From: Amanda Scholes on behalf of Planning.Responses
Sent: 02 December 2020 13:15
To: Planning Scanning
Subject: FW: P/97/20/PL- Land To North Of Summer Lane Pagham

Application Correspondence "Request for local drainage improvements"

From: Simon Davis
Sent: 02 December 2020 12:39
To: [REDACTED]
Subject: P/97/20/PL- Land To North Of Summer Lane Pagham

Drawing Title
Proposed Site Plan
105 Unit Scheme

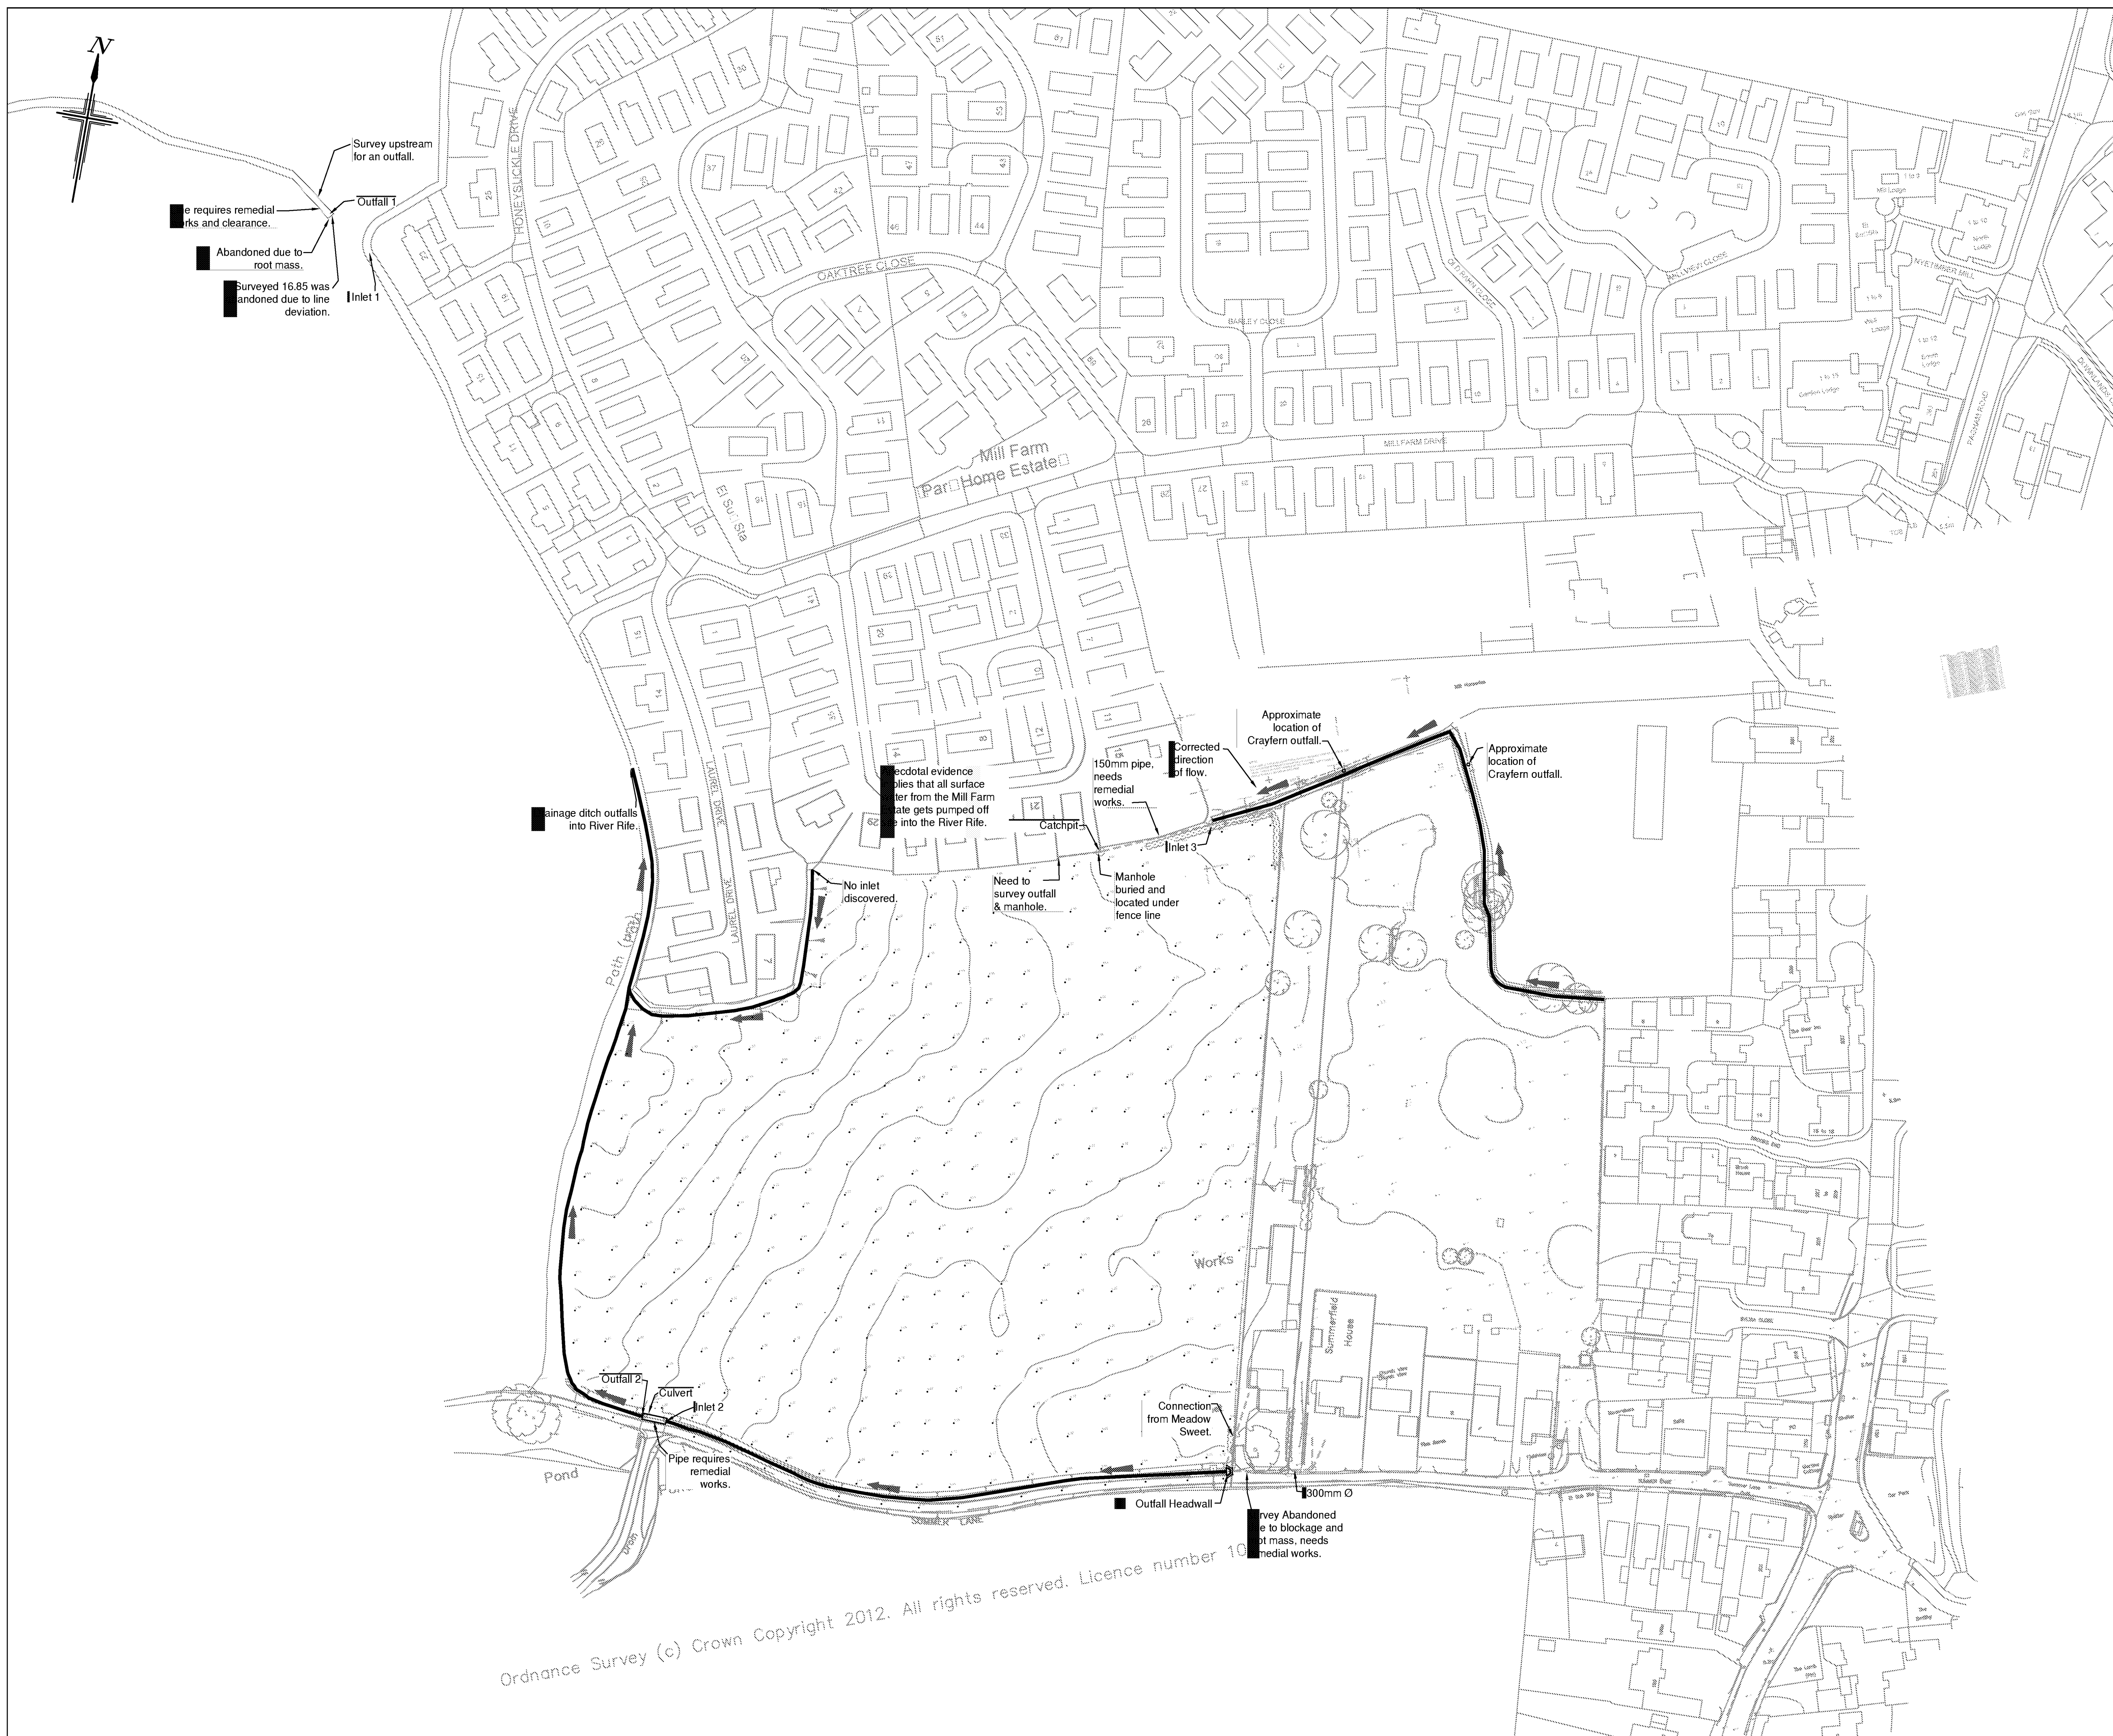
"The proposed revised development layout has not been designed in accordance with the WSCC Culvert Policy, which is not in favour of culverting existing open watercourses. The current proposal will result in around 50m of current open watercourse being culverted. Better consideration to current WSCC policy and a revised layout could have reduced the ecological effects that this proposed development will have on the local ditch network."

I can see that capacity will not be an issue, as the ditch is being increased in size to accommodate the proposed 750mm culverts and it would appear that, in fact, ecology is not seen to be an issue due to the proposed ecological mitigation. Therefore, it would be difficult to object to this proposal.

However, as this culverting goes against our current policy, I believe that the developer should be asked to provide further local improvements within the existing ditch network, to be agreed with Arun DC, to further mitigate to effects of this culverting."

I therefore write to ask whether you are able to provide further local improvements within the existing ditch network. If you wish to discuss this matter then you can contact ADC's engineers, Paul Cann or Laura Gibbons. Please also note that you would need separate Land Drainage Consent for the culverting and our Engineers may raise the same concerns at that time.
